## Building Permit #2017-01190, 89 Pleasant Ave., PI

1/31/18

Code review per the [One and Two Family Addition/Alteration Checklist](#):

### SECTIONS

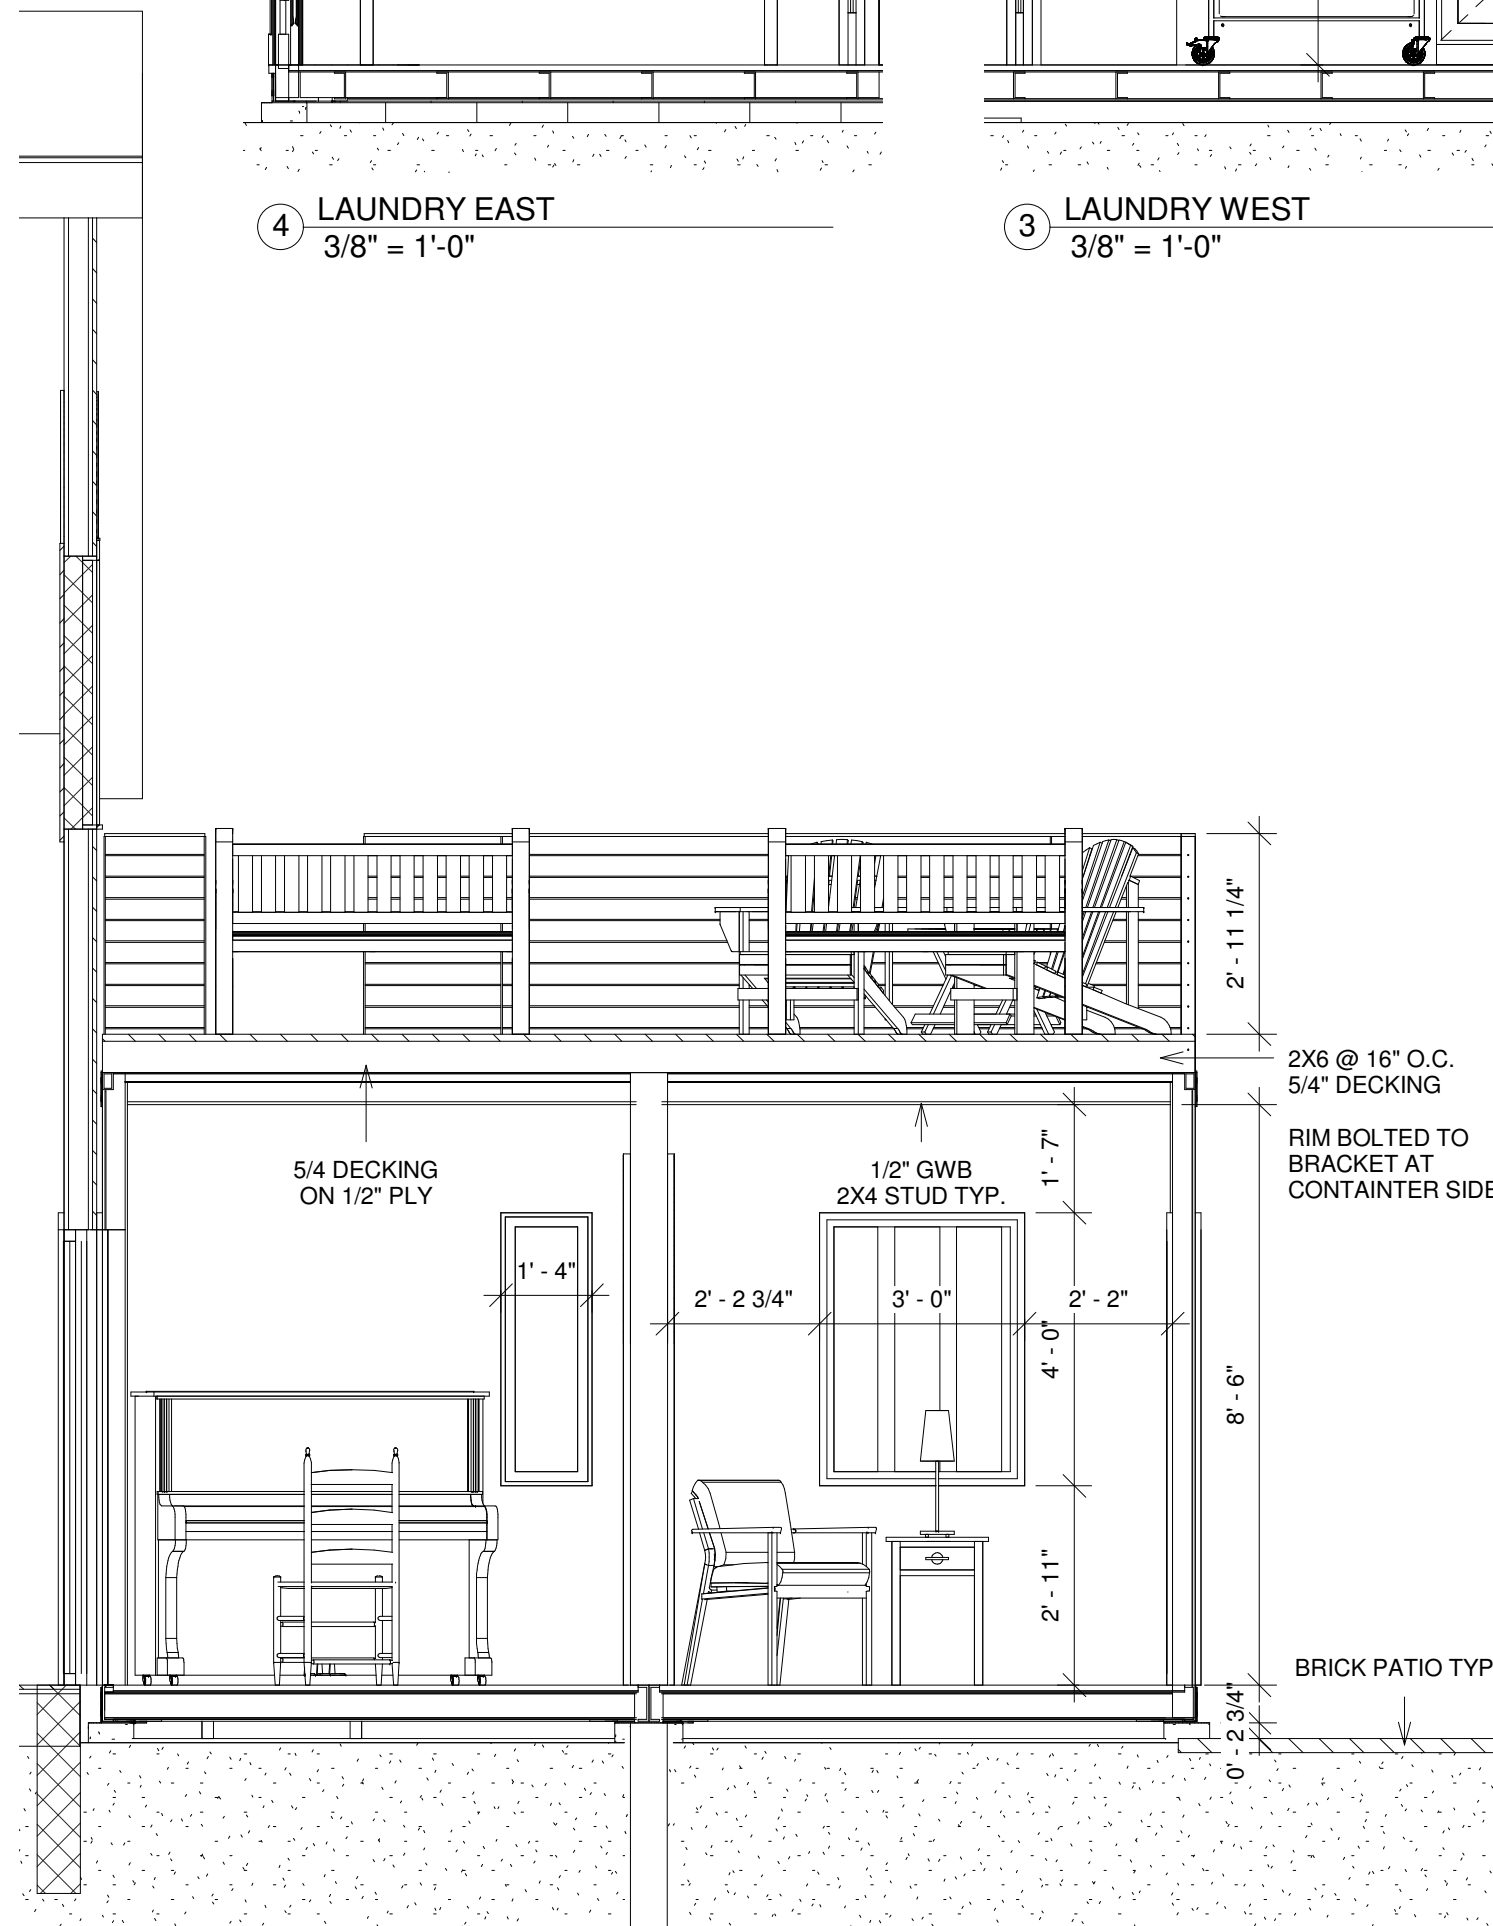
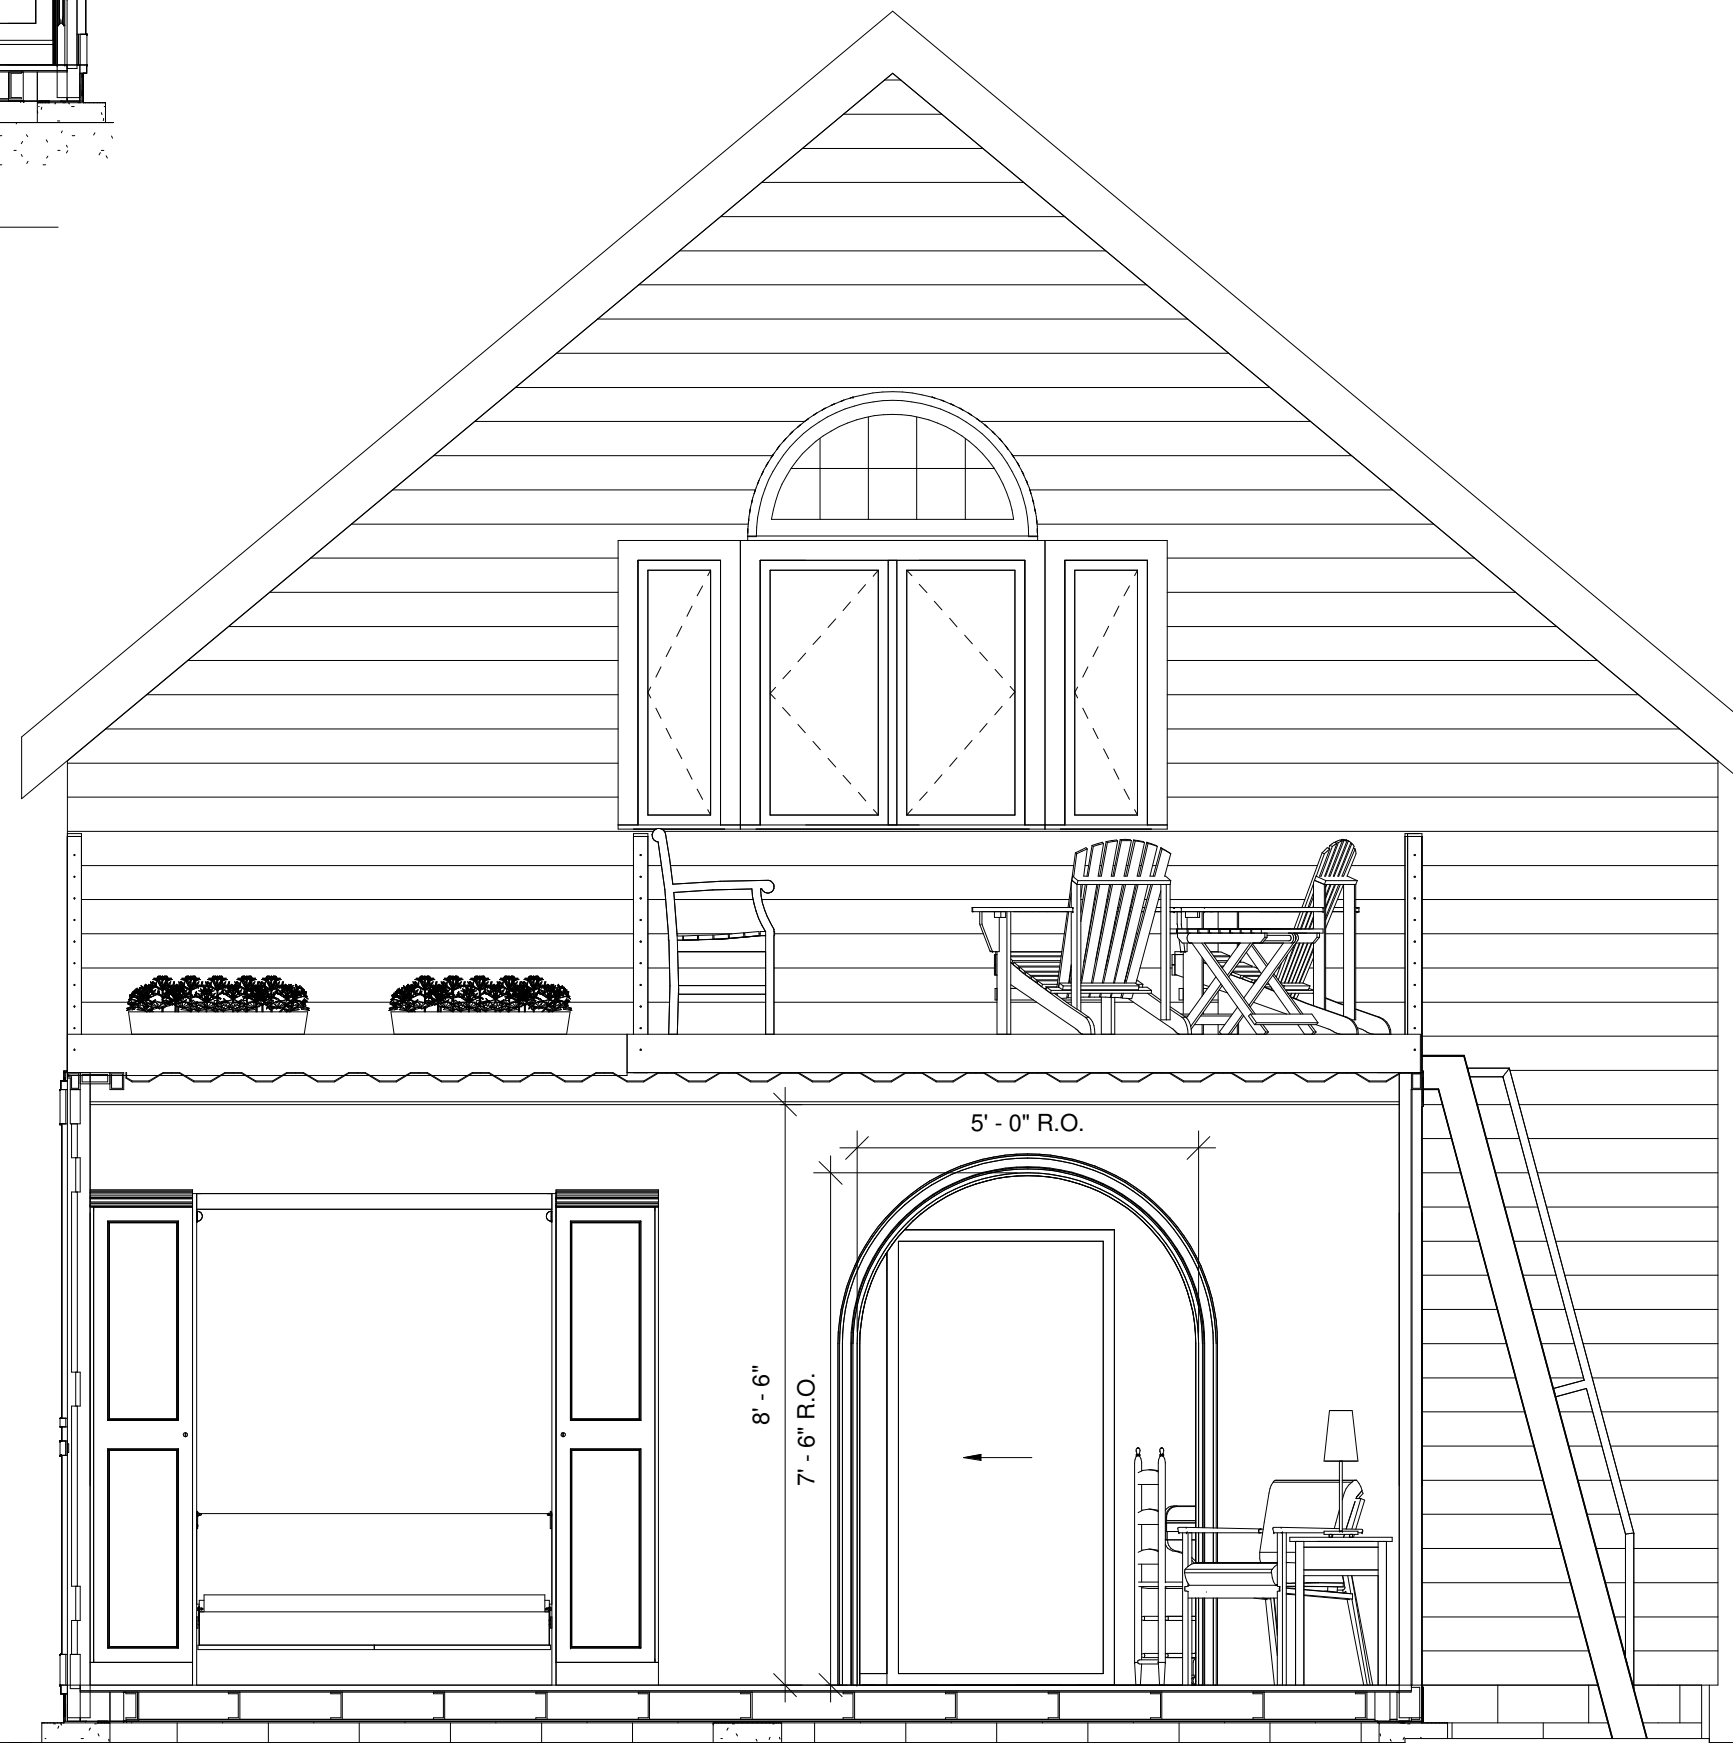
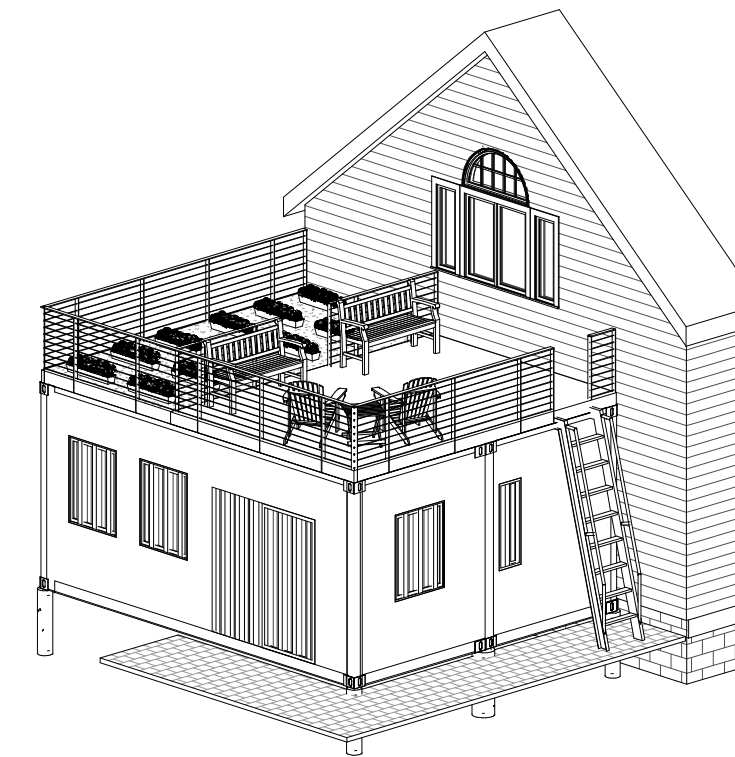
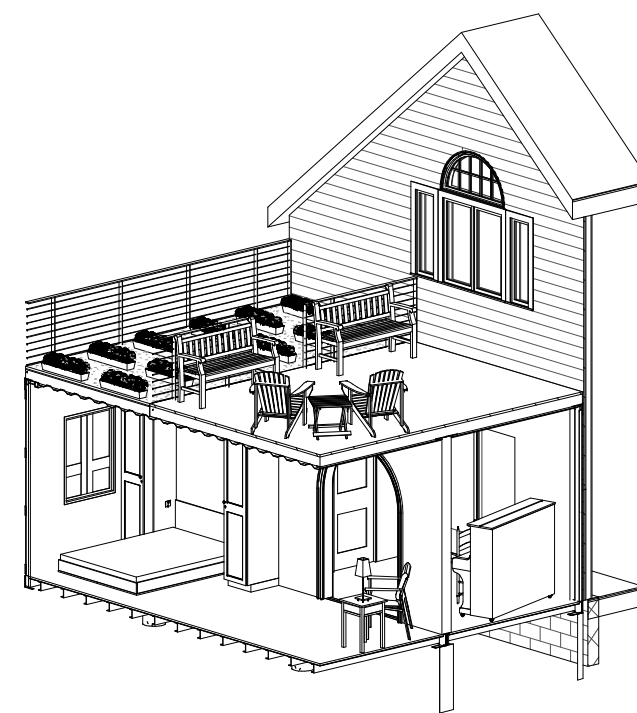
1. Structural plans for the modified shipping container.
2. Structure anchoring specifications and details.
3. Footing & pier dimensions, depth, and reinforcement.
4. Insulation R-factor levels for floor, walls and ceiling.
5. Window and door schedule including U-factor levels.
6. Smoke and carbon monoxide locations.
7. Construction of any new exterior landing, steps and railings based on the height off grade.
